Engineers Comments Regarding Surface Water Drainage

Application Reference:	A/183/25/DOC	Reviewer Reference:	ADC/EXT5/AF
Planning Officer:	Harry Chalk	Date of Review:	23/12/2025
Site Name:	Land north of Mayflower Way Angmering		
Application Description:	Approval of details reserved by condition imposed under A/122/23/PL relating to condition 11-surface water drainage.		
Assessment Number:	1

Response	Condition 11: Objection
-----------------	--------------------------------

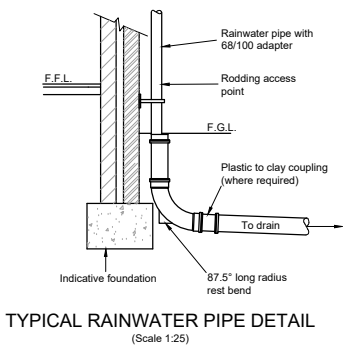
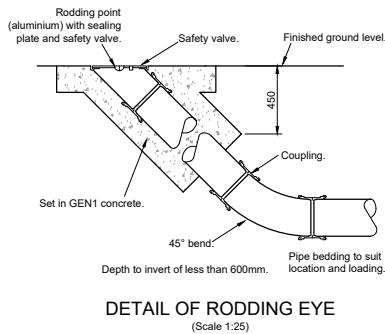
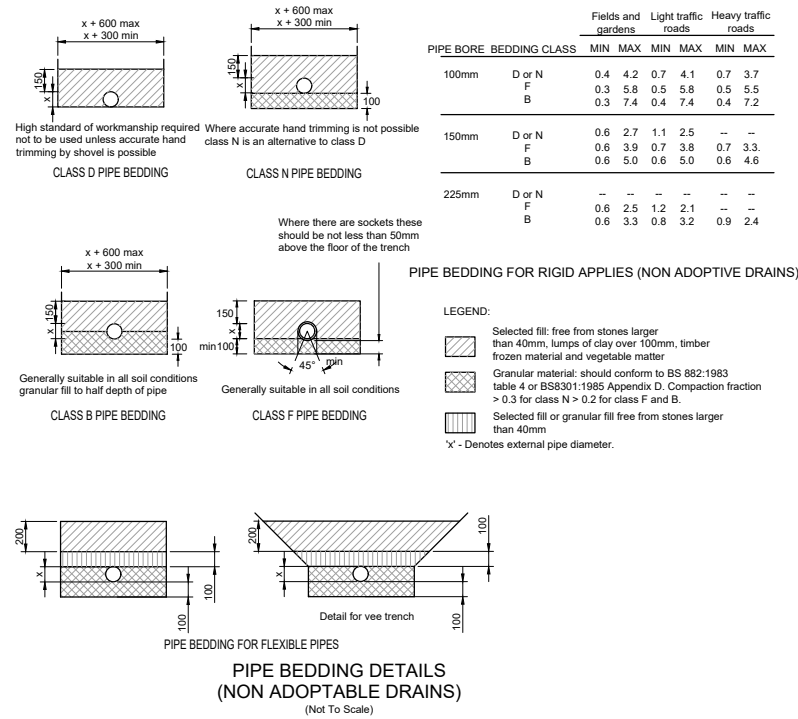
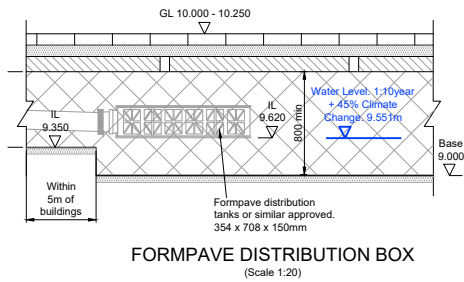
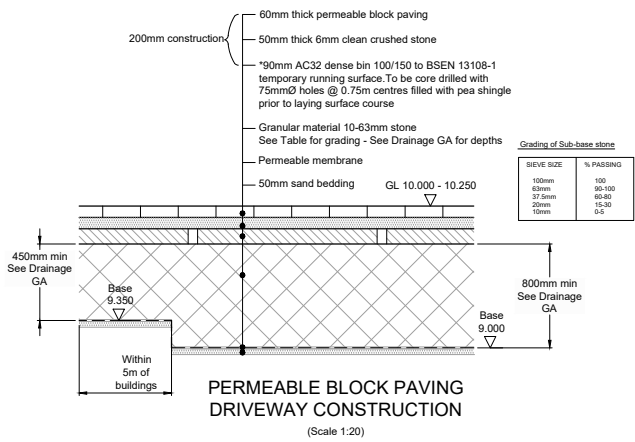
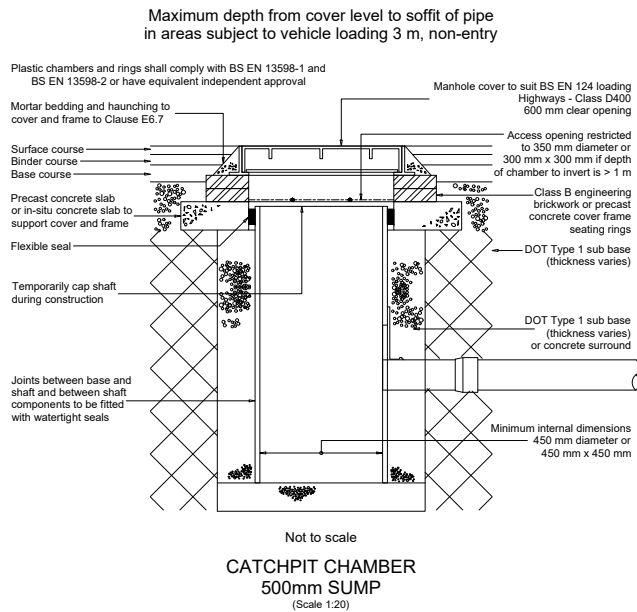
ADC Drainage Comments	Designer Response			
Date:	23/12/2025				
Condition Number: 11					
Comment Number					
1.	The factor of safety for the base infiltration rate should be increased in accordance with the NSfS.				
2.	The paved area around the house is impermeable and appears to drain towards the permeable pavement but is excluded from the drained area.				
3.	The half drain time for the 3/3AEP+CCA storm should be demonstrated to be less than 24 hours based upon the entire drained area.				
4.	The drainage layout should show a Stage 4 Technical Design rather than Planning Strategy Plan and include full levels design. The layout

should show the permeable pavement base levels rather than depths.				
5.	The MMP should be a final version standalone document and not interim attached to the discharge of conditions report. The drainage plans should be appended together with a proforma inspection and maintenance checklist.
